# Engineers Comments Regarding Surface Water Drainage

<b>Application Reference:</b>	AL/84/25/PL	<b>Reviewer Reference:</b>	ADC/KW and SB
<b>Planning Officer:</b>	Harry Chalk	<b>Date of Review:</b>	19/11/2025
<b>Site Name:</b>	The Grange, Westergate Street, PO20 3SQ		
<b>Application Description:</b>	Removal of mobile home and replacement with 1 No self build dwelling and associated works (alternative to AL/150/22/PL).		
<b>Assessment Number:</b>	1 of 1

**Foul and Surface Water Drainage Report 10 June 2025 Rev P1**

CONTRIBUTING AREA PLAN (scale 1:200)

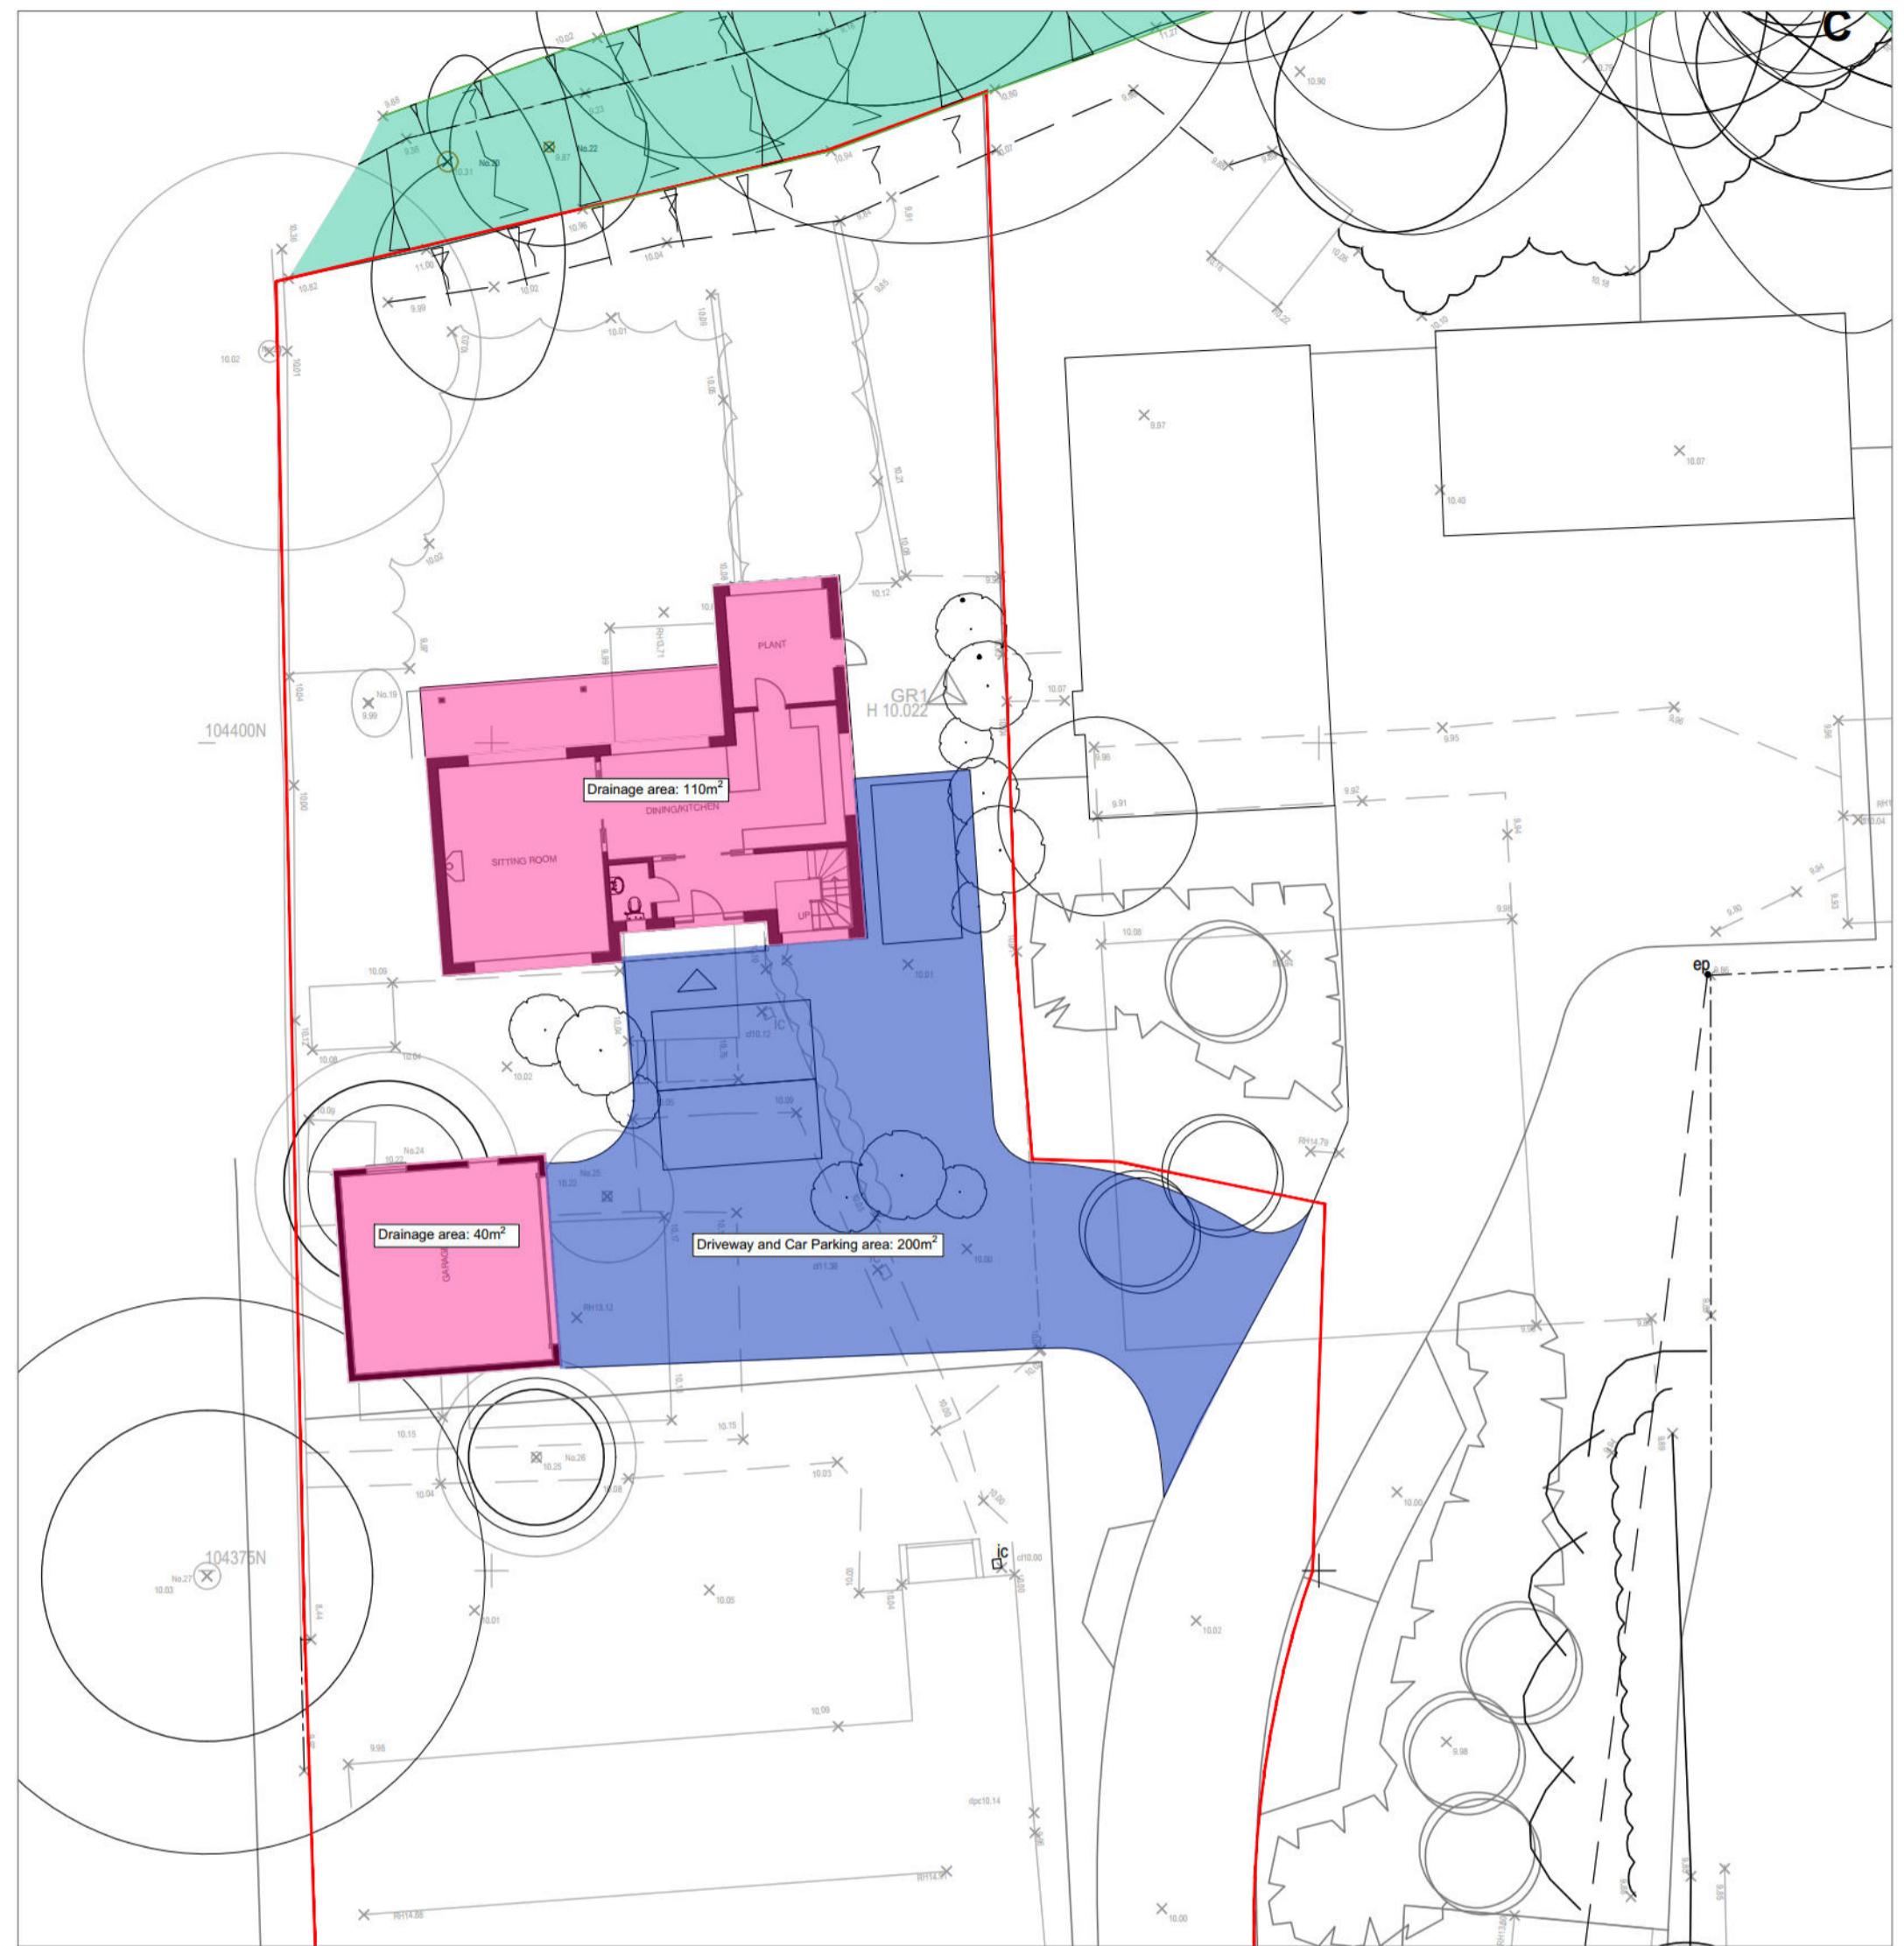
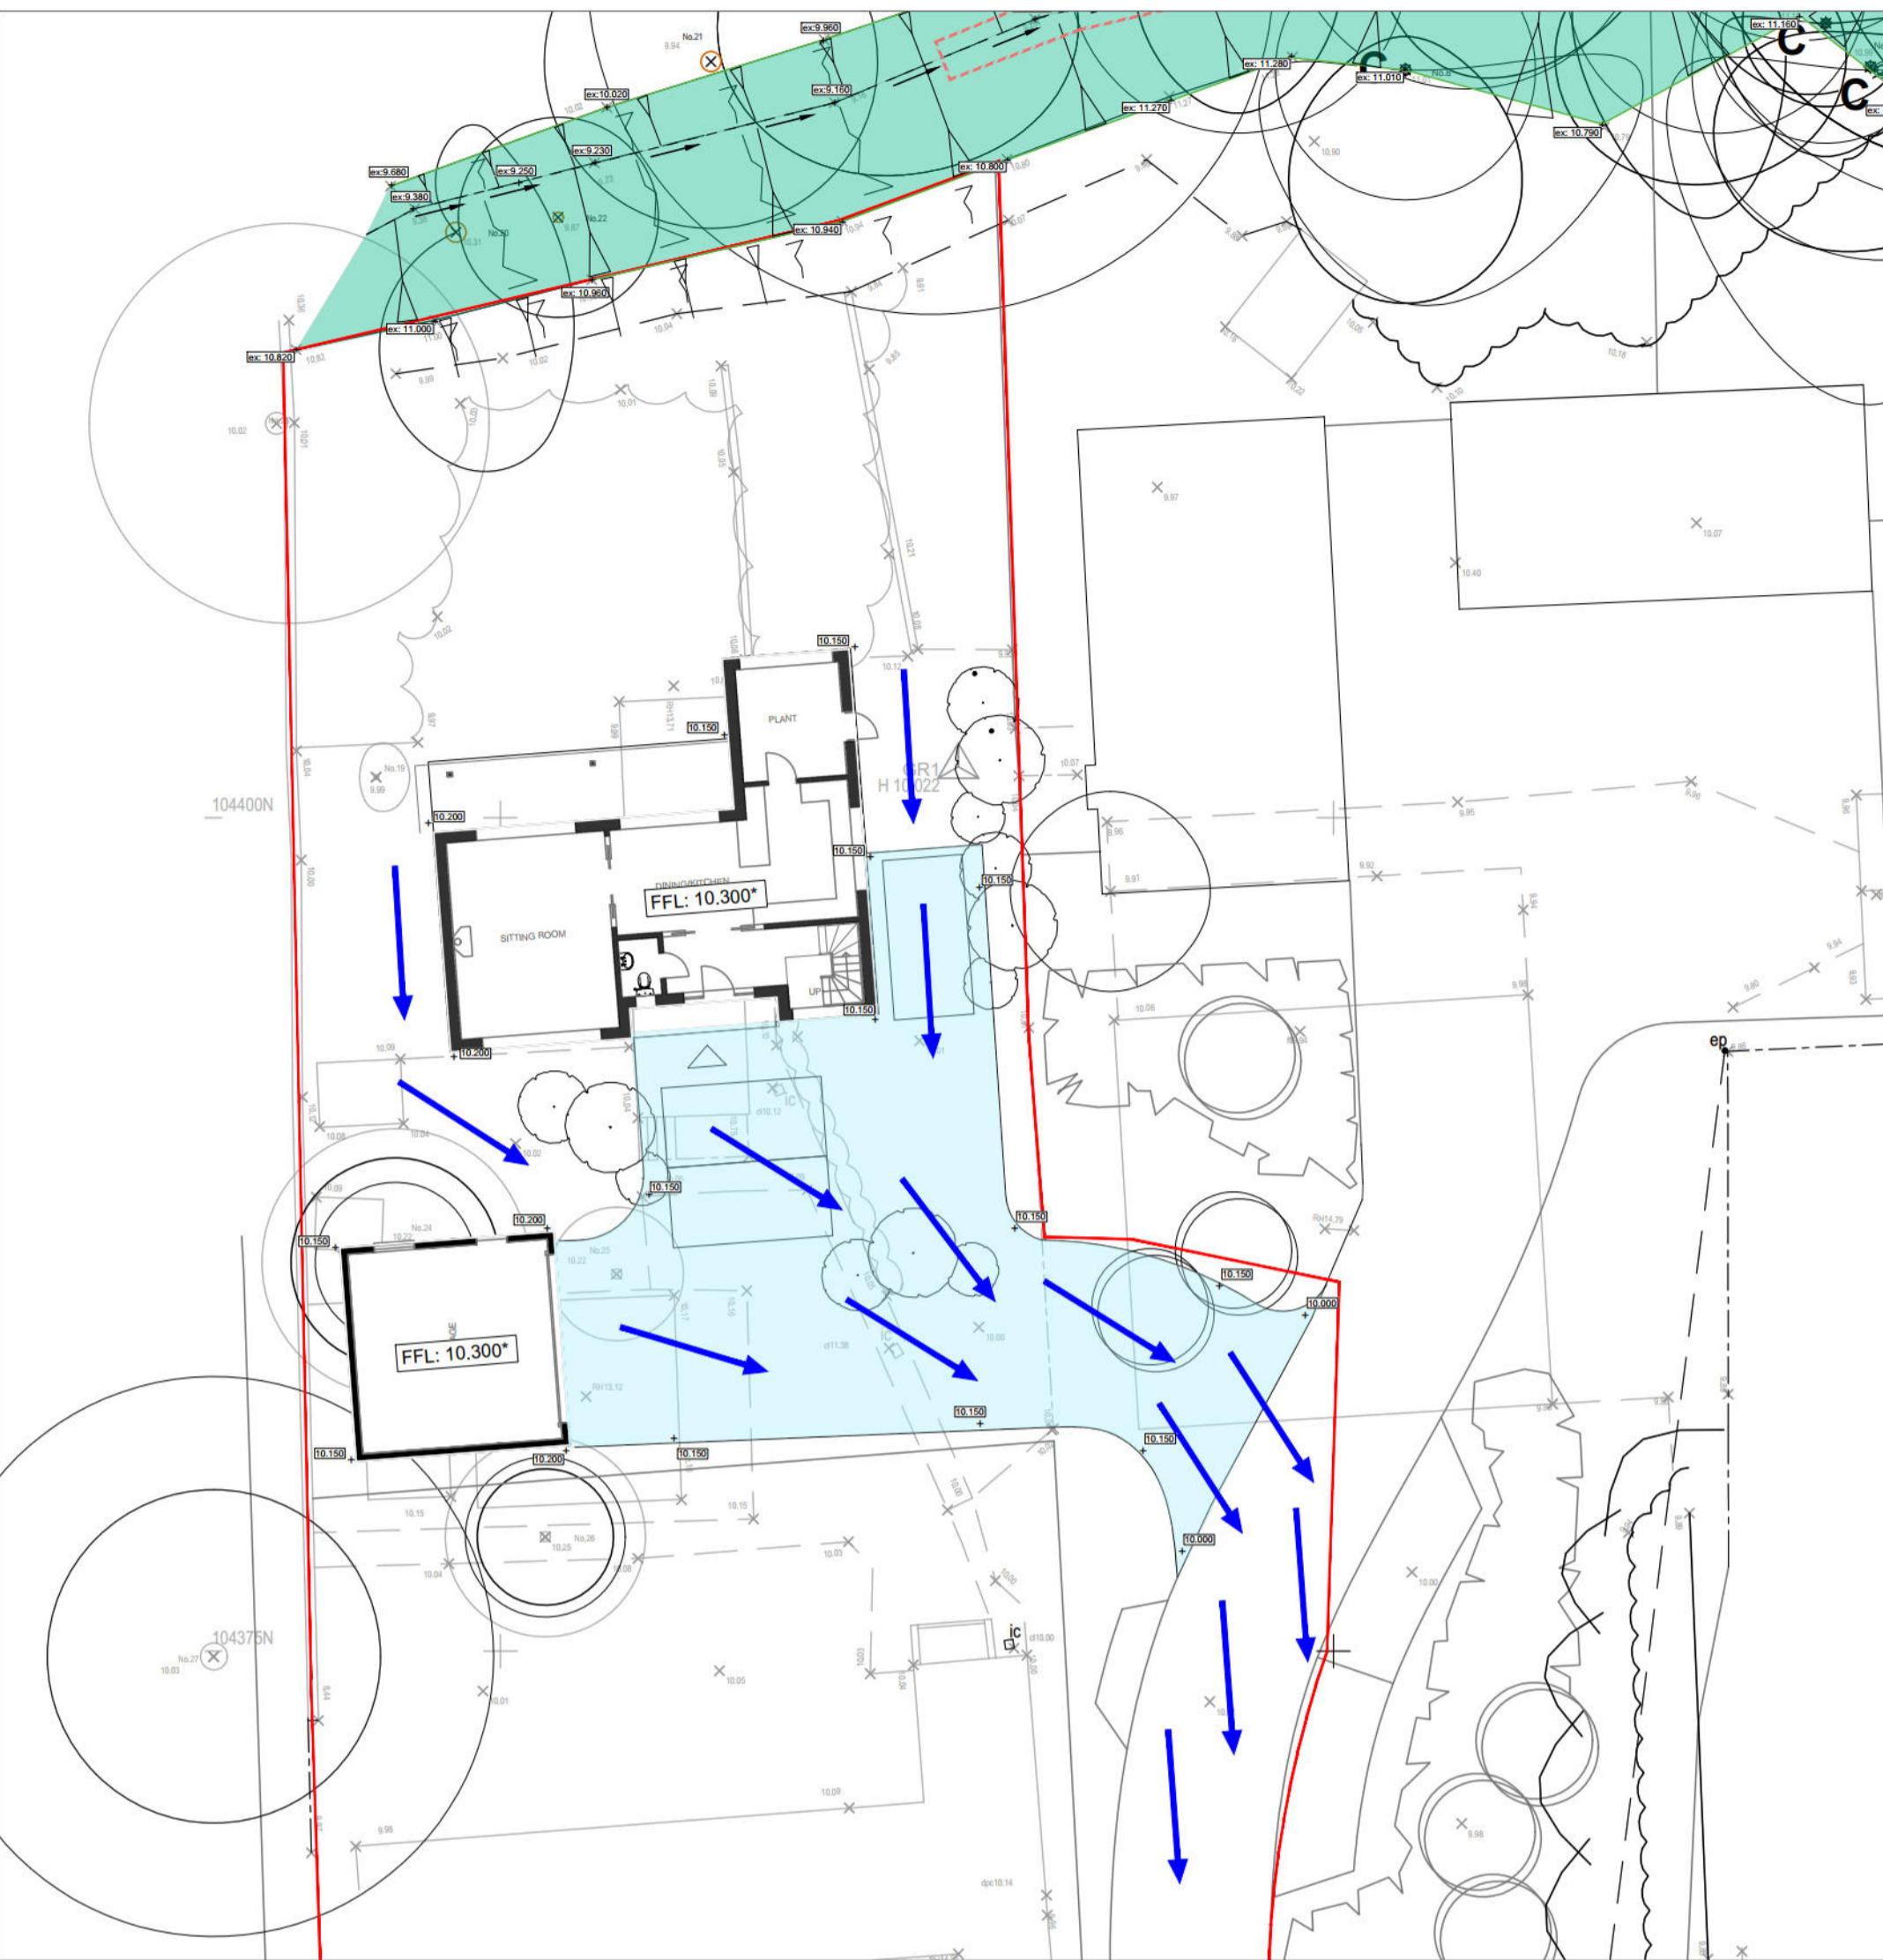
- 3.3. Surface water drainage calculations require checking; the designer should ensure that plans and calculations accurately correspond. For example, the cover level for the permeable paving input into the calculations does not reflect the lowest cover level shown on the plan. This artificially increases the storage depth in those areas, affecting the storage volumes within the paved attenuation feature. The network model must be accurate for the shallowest depth of storage.

- 3.4. Furthermore, an incorrect porosity value of 1 has been afforded to the bioretention planter, when in reality the substrate present in the planter will impact the storage volumes available.
